12 June 2026

Re: Objection to Proposed Tirawley Wind Farm Strategic Infrastructure Development

Case Reference: PAX16.324258

| Title | PROPOSED BATTERY STORAGE FACILITY COMPOUND ELEVATIONS - SECTION | | | | |

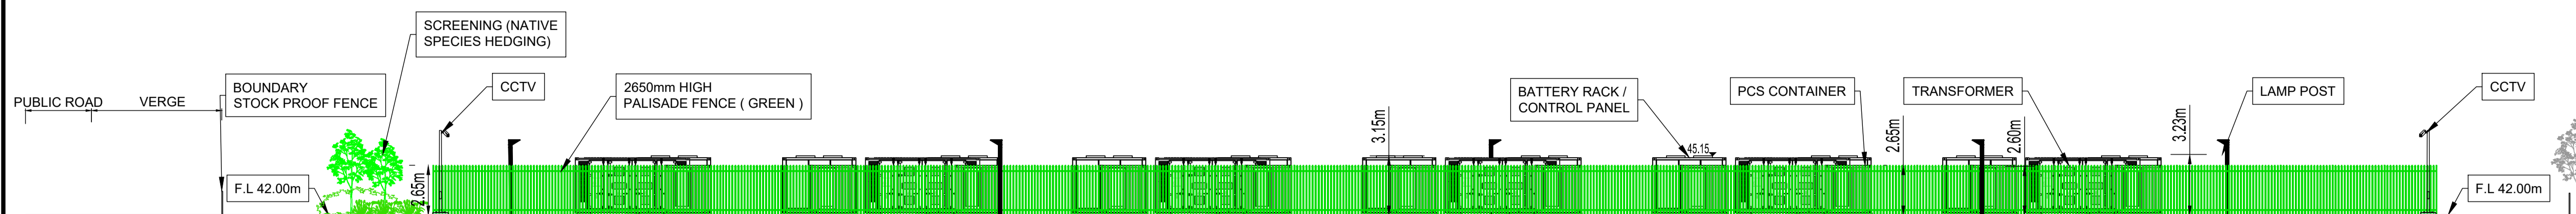
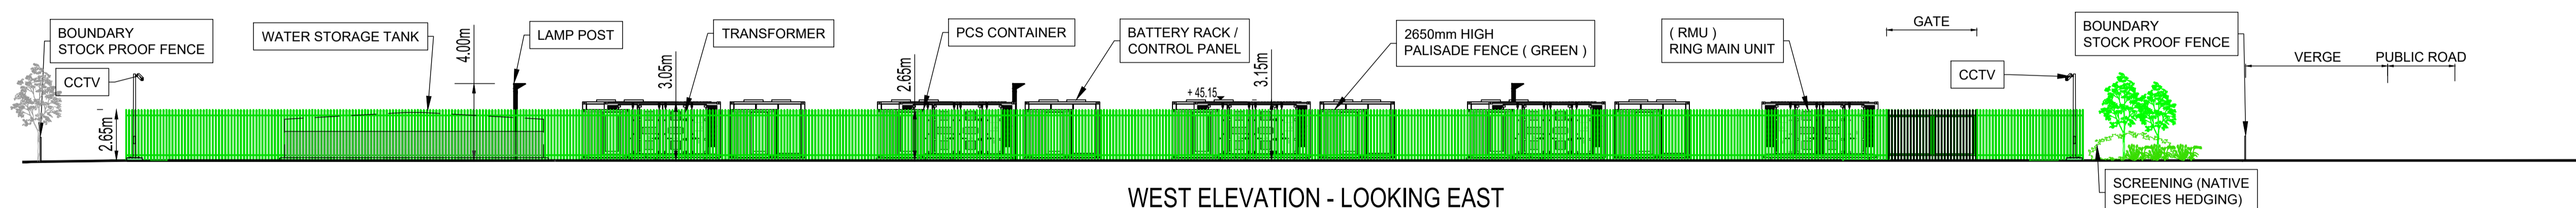
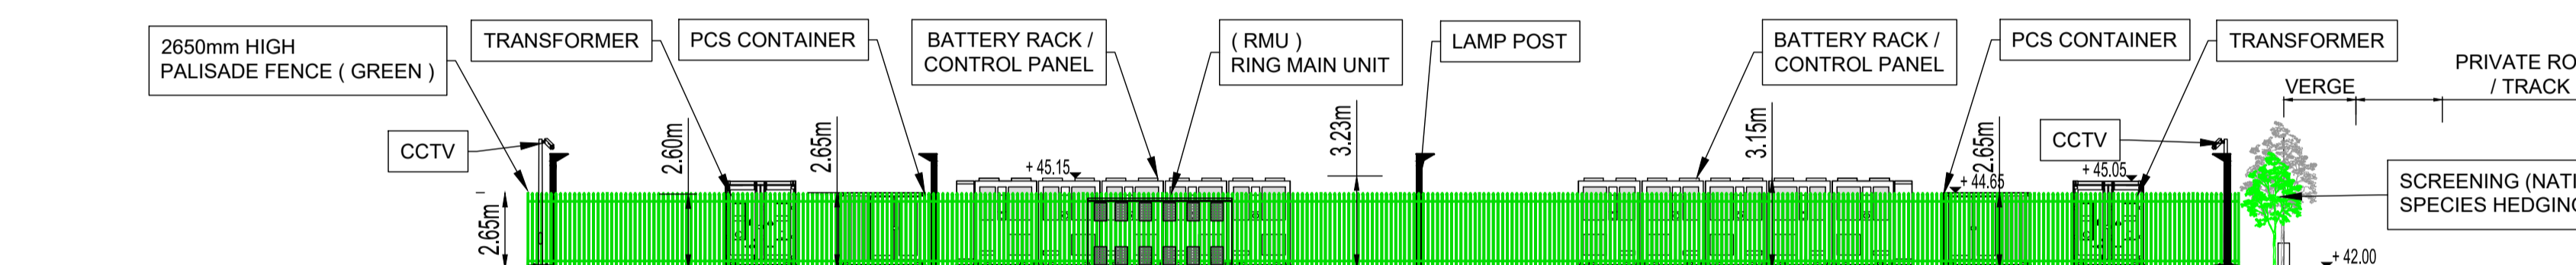
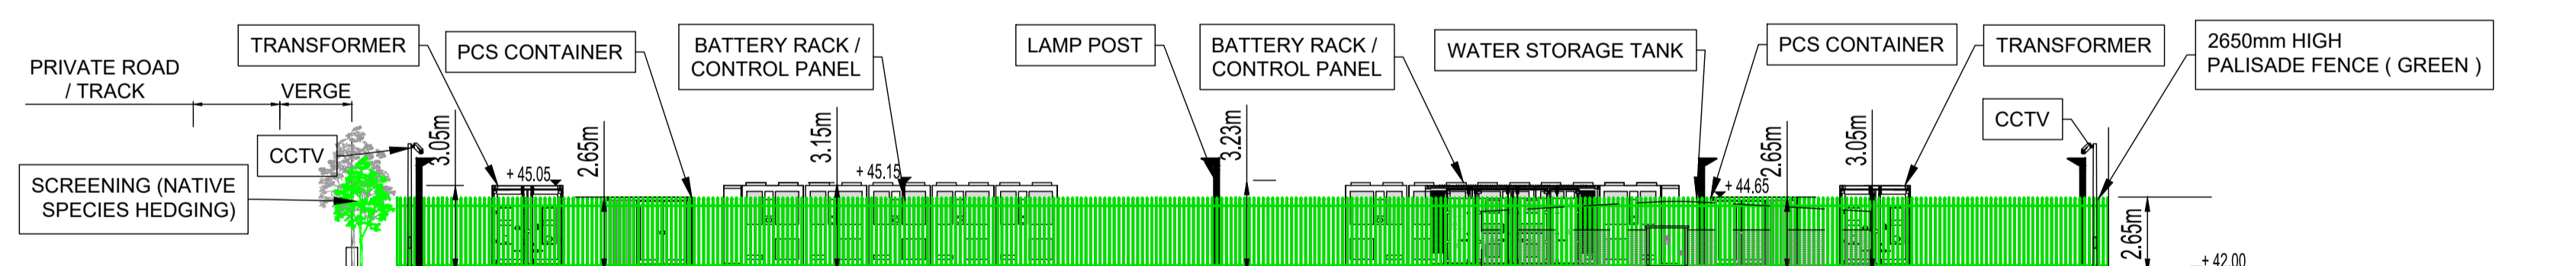
The proposed BESS located just 432 metres from my health that I use, will consist of approximately twenty containerised battery storage units capable of storing up to 150 MW of electricity. While presented as ancillary infrastructure, the BESS is in reality a substantial industrial facility with significant inherent risks.

The applicant's own documentation acknowledges that battery storage technology presents fire safety challenges and that fire safety guidance relating to BESS facilities remains an evolving field. The Fire Safety Assessment confirms that thermal runaway events remain a recognised risk and that current emergency response strategies often involve allowing batteries to burn themselves out because extinguishment can be extremely difficult.

Of particular concern is the fact that internationally recognised guidance in some jurisdictions has adopted precautionary separation distances of up to 500 metres from BESS facilities due to uncertainty regarding thermal runaway events and fire propagation. No such precautionary approach appears to have been adopted in this application.

The BESS compound alone occupies approximately 6,360 square metres, excluding the substation and associated infrastructure.

The proposed 2.6-metre-high palisade fencing, lighting, transformers and industrial structures will fundamentally alter the character of the landscape and introduce an industrial appearance entirely inconsistent with the existing rural setting.
